THIRU PAVAN RAINA, I.A.S.,  
Member-Secretary,  
Madras Metropolitan  
Development Authority,  
No.8, Gandhi-Irwin Road,  
Egmore, Madras-600 008.

Letter No. D.Dls.A3/3739/91

Sub: MMDA - Planning Permission - ~~Cons-~~  
struction of residential building cum  
Shop in Plot No.2 at S.No.42/1 of  
Nanganallur village - Approval - Reg.

SITE PLAN

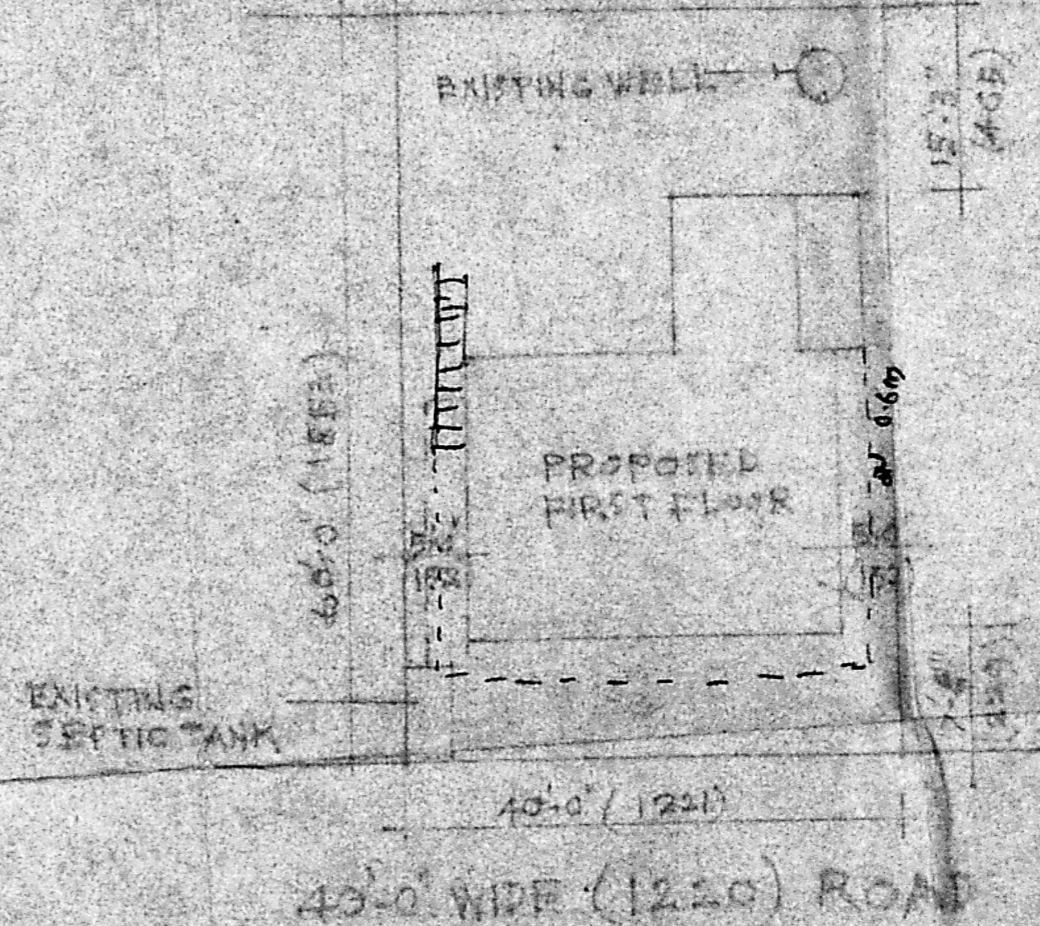
The Planning Permission proposal received in the  
reference cited for the construction of Residential cum shops  
building in Plot No.2 at S.No.42/1 of Nanganallur village was  
examined and found that the planning permission for the same is  
issuable after relaxing Front Set Back is 2.29m against 3m and  
0.6m instead of 1.5m and subject to condition that —
